Comments for Planning Application 220529/DPP

Proposal: Erection of restaurant (class 3) with drive thru facility (sui-generis) including installation of 2no. customer order displays, post height restrictor and play frame; car parking, landscaping and associated works including demolition [cr]

Stance: Customer objects to the Planning Application

ARCHITECTS LAYOUT

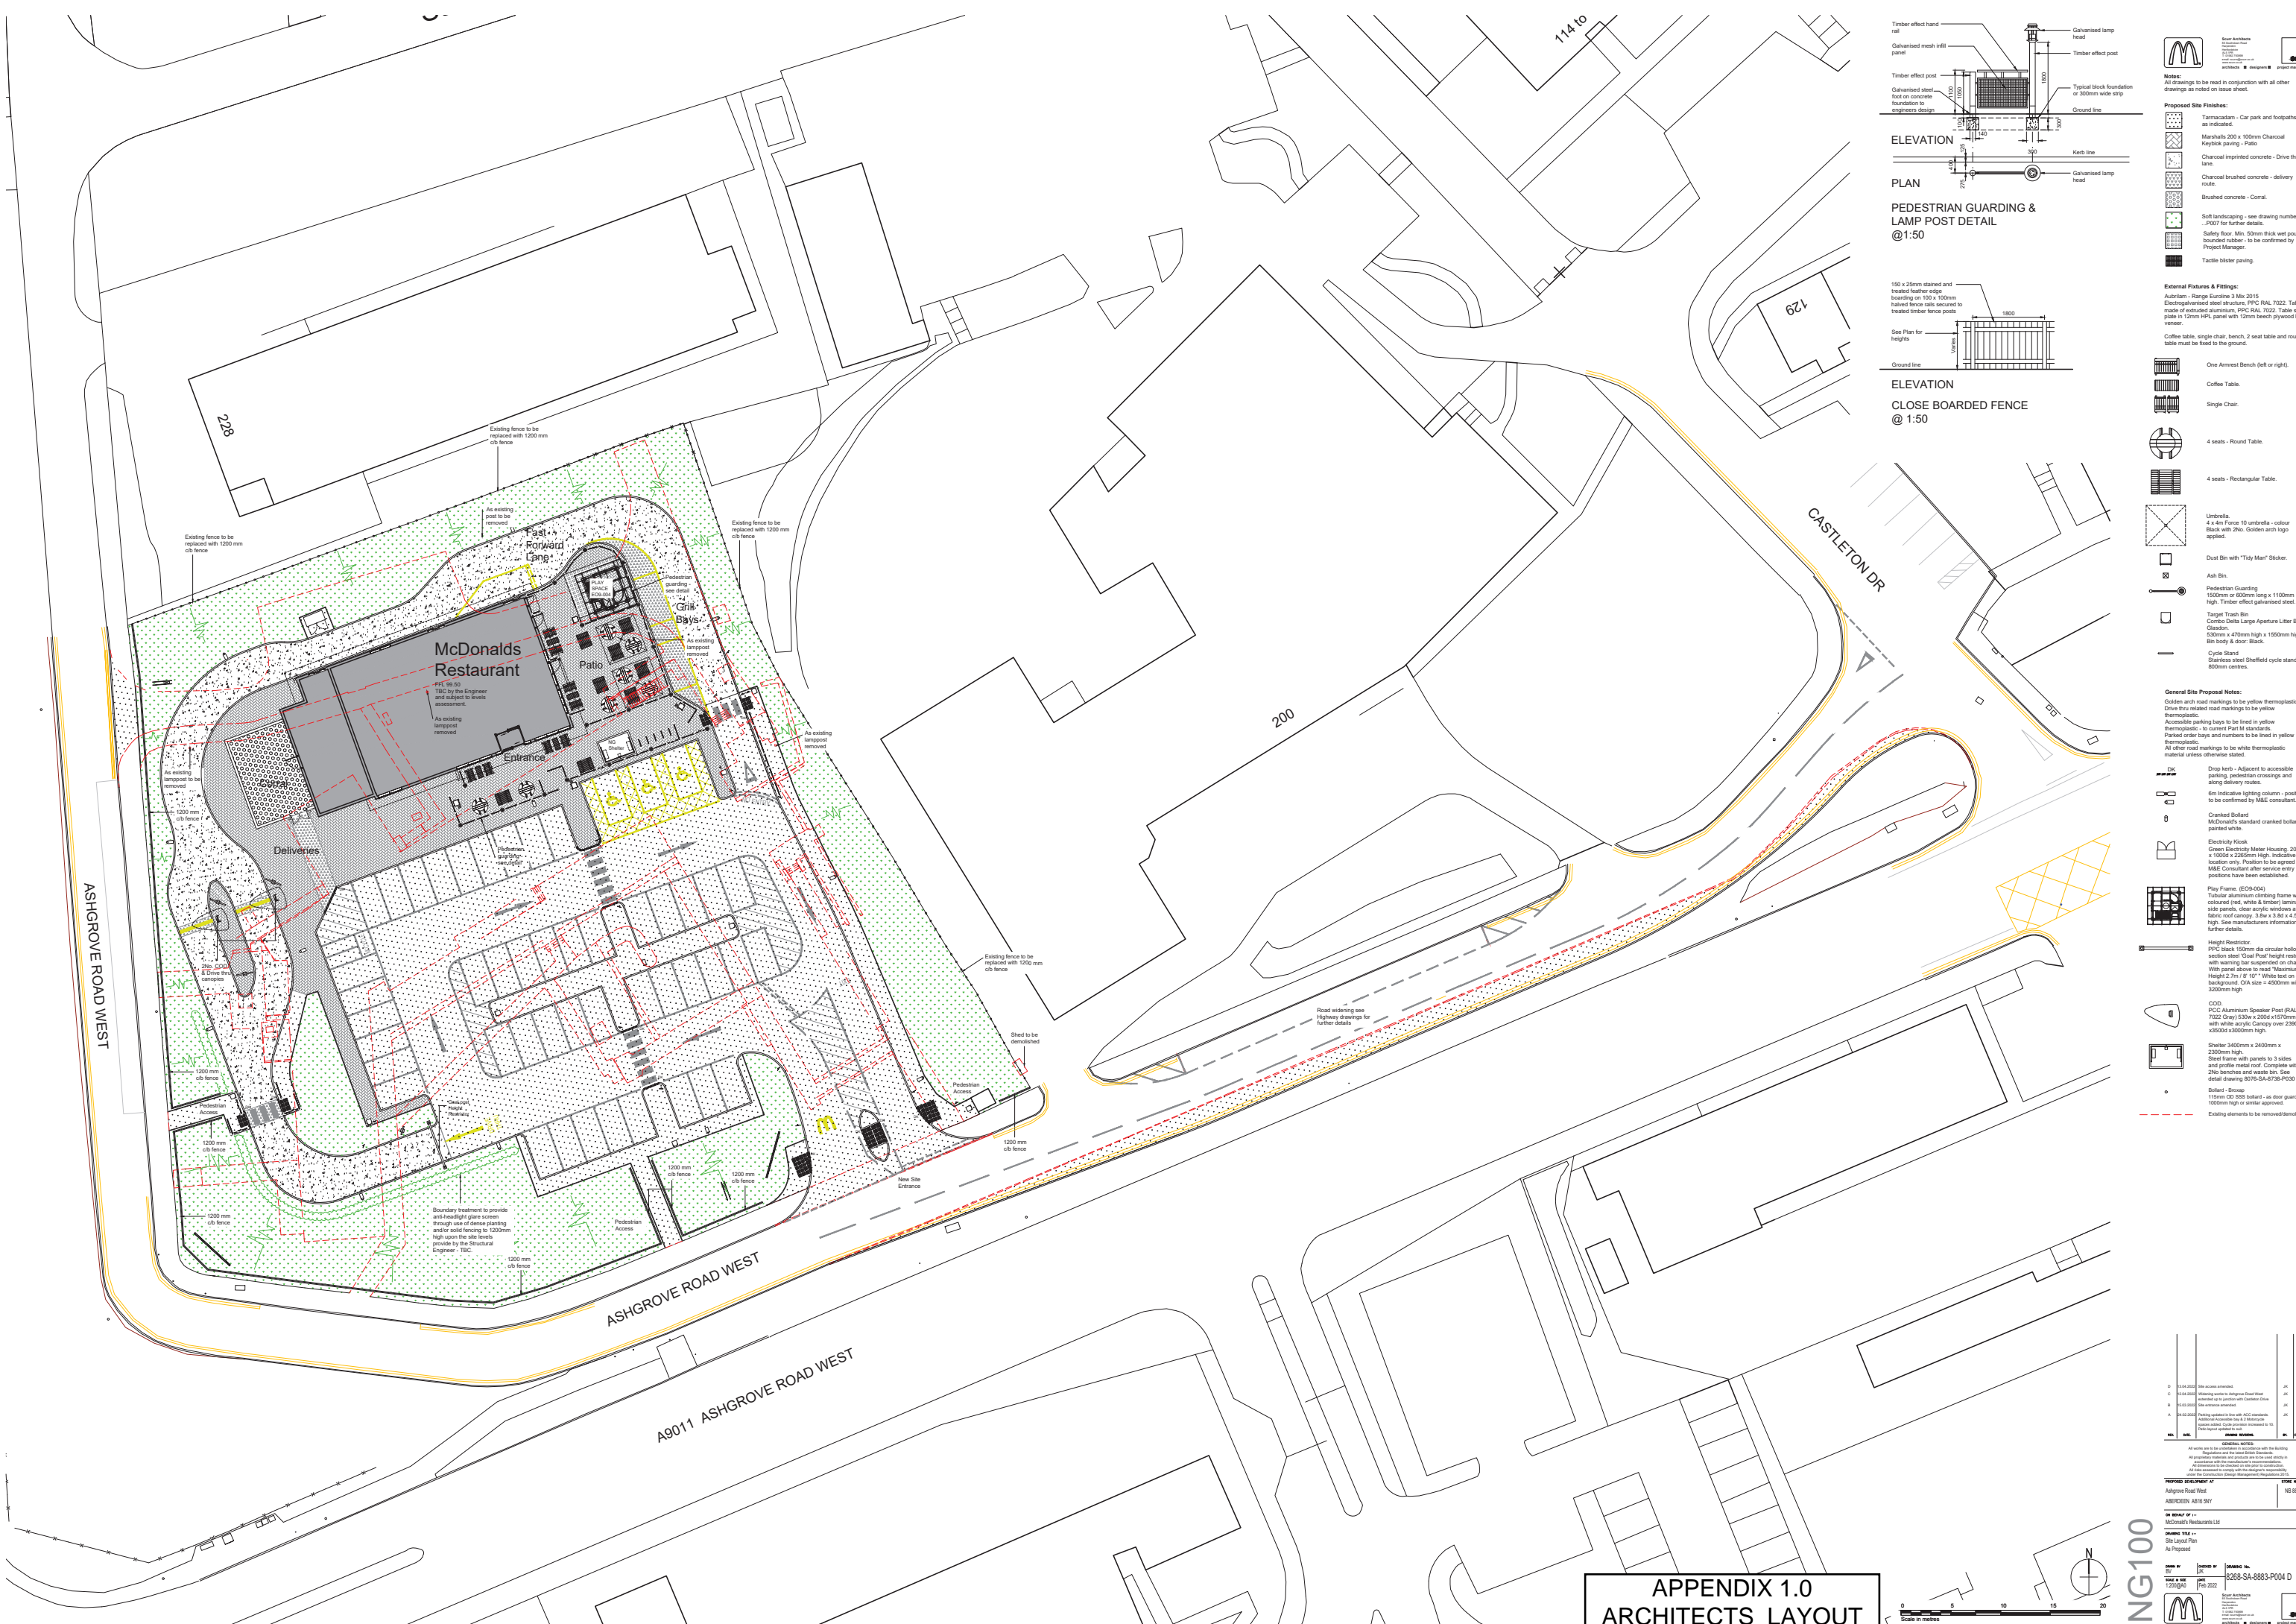
Comment: This non-residential development lacks active Electric Vehicle (EV) charging provision, of which is required under the 2022 LDP about to be adopted and the 2017 LDP in place. Where all parking facilities at non-residential developments should include them. The 2017 LDP Guidance requires for 50 parking spaces would require at a minimum 2 active chargers and 2 passive.

Although, I would suggest as an EV driver myself, there should be 4 active chargers from the opening of the development (with that being conditioned by ACC). Sales of new cars with plugs are currently at 1 in 4 sold. This would be a benefit for the local community, as well as customers visiting for food, it would also help bring in more custom. This is also in line with the aims of the Scottish and UK Govts in reducing air pollution in Cities.

Owing to the length of time spent there, Rapid or faster (ie 50kW or higher) chargers would be best suited not the slower AC 7-22KW and I would also suggest one of the charging bays is accessible disabilities wise to meet incoming BSI standards this Summer.

Until provisions for EV's are made in this application, I have to object.
